From: Neil Crowther
Sent: 14 November 2014 13:01
To: Planning.Responses
Subject: FW: C14443 RE: Oldlands Farm - Surface Water Drainage Conditions BE/121/14 DOC

Further to your points raised in your email 22 October 2014 (attached for your reference) we would like to offer the following response.

Typical Separator + Rainwater Harvesting Tank Installation Detail (Scale 1 : 50)

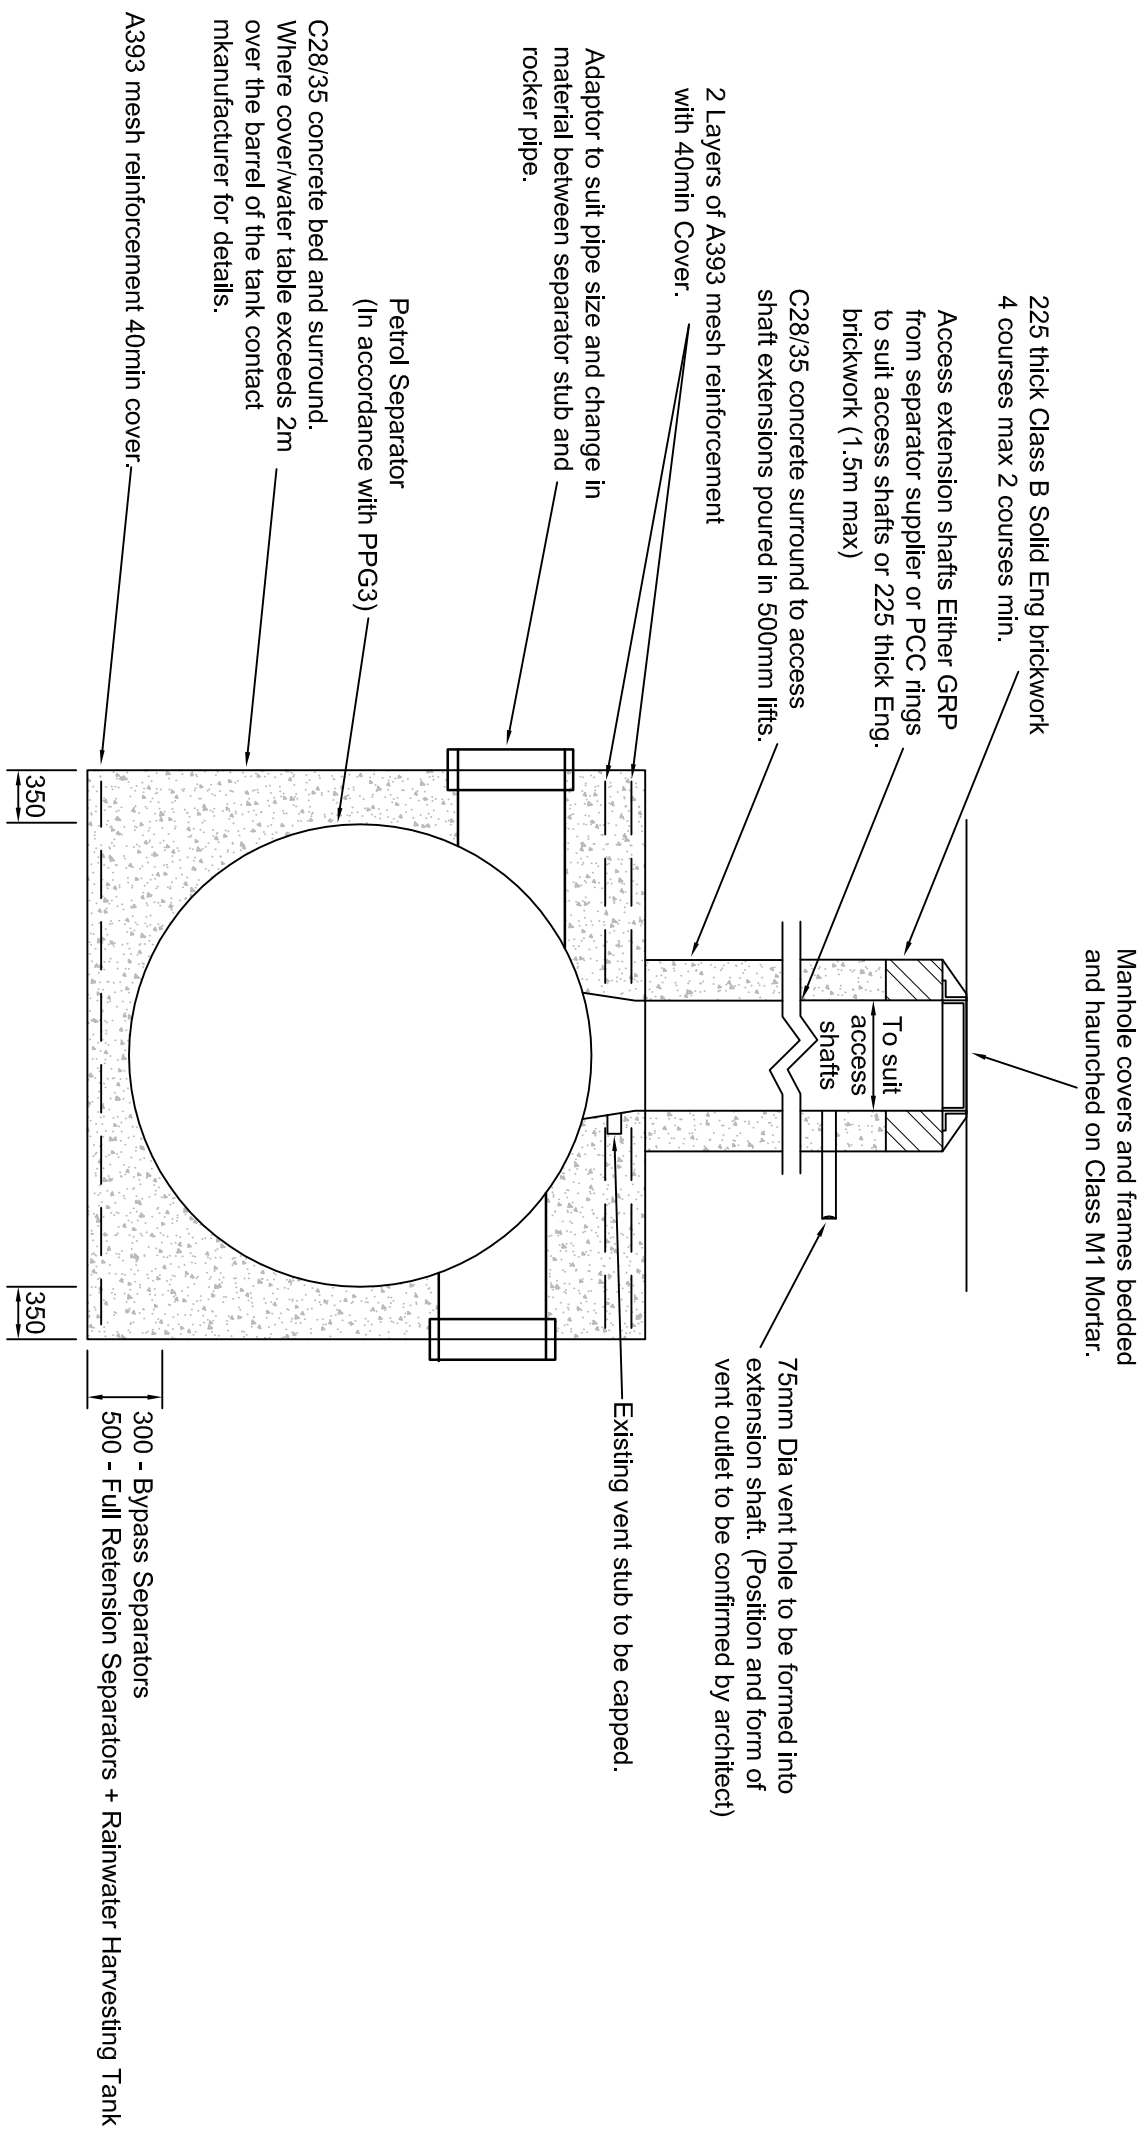
5. Outflow from pond to dry ditch has been angled further to direct flows into the channel.
6. The planning condition does not ask for construction drawings of the details you mention which will be submitted as part of the building control approval process. Drawing 220 attached gives outfall options for the contractor to price, it is likely that a precast outfall will be used. Given the nature of the ground, there will be no liner to the pond.

PLAN ON ATTENUATION POND  
Scale 1: 500

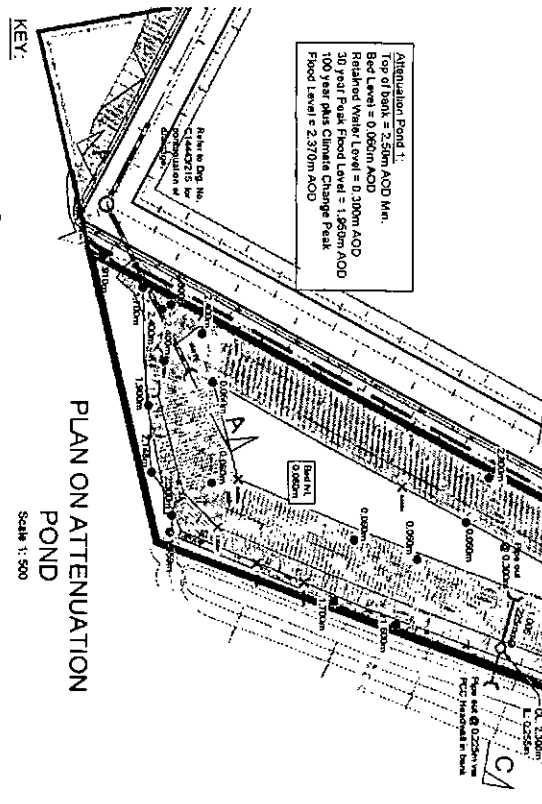
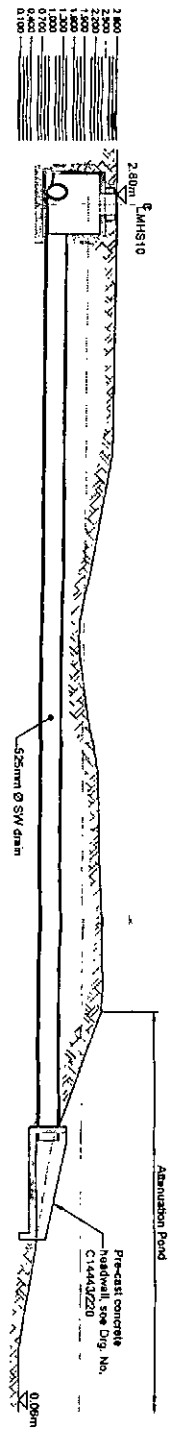
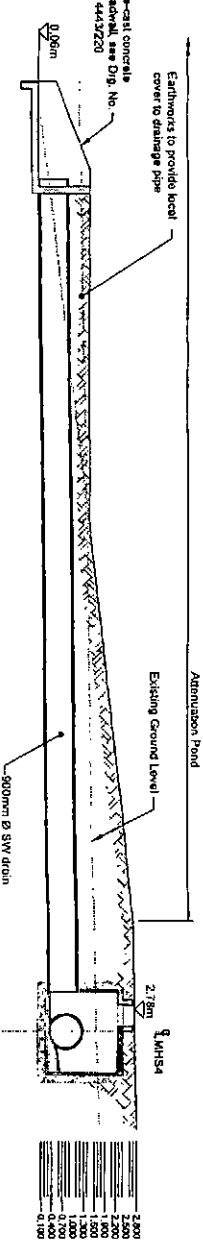
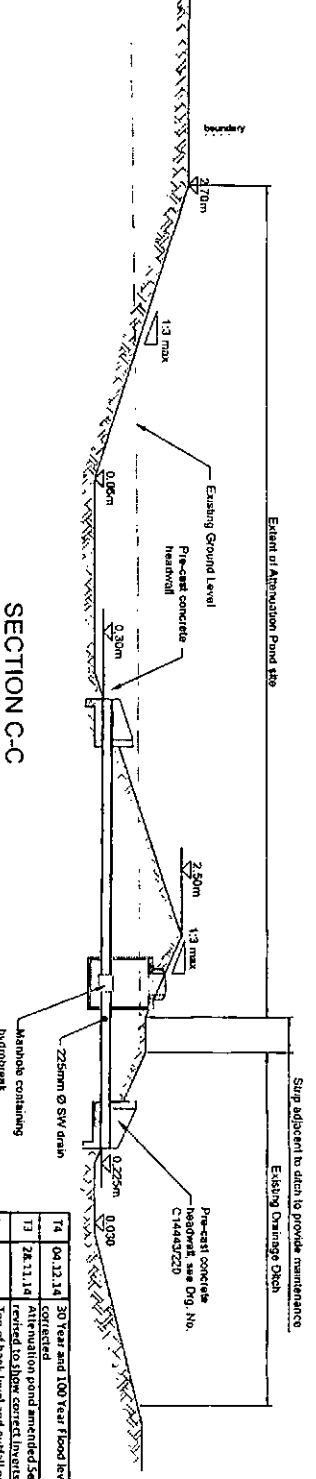
2. While we don't believe there is any guidance to support the case for 300mm freeboard. Recent re-modelling of the pond is providing the level of freeboard you would like to see. I attach the latest pond layout for reference.
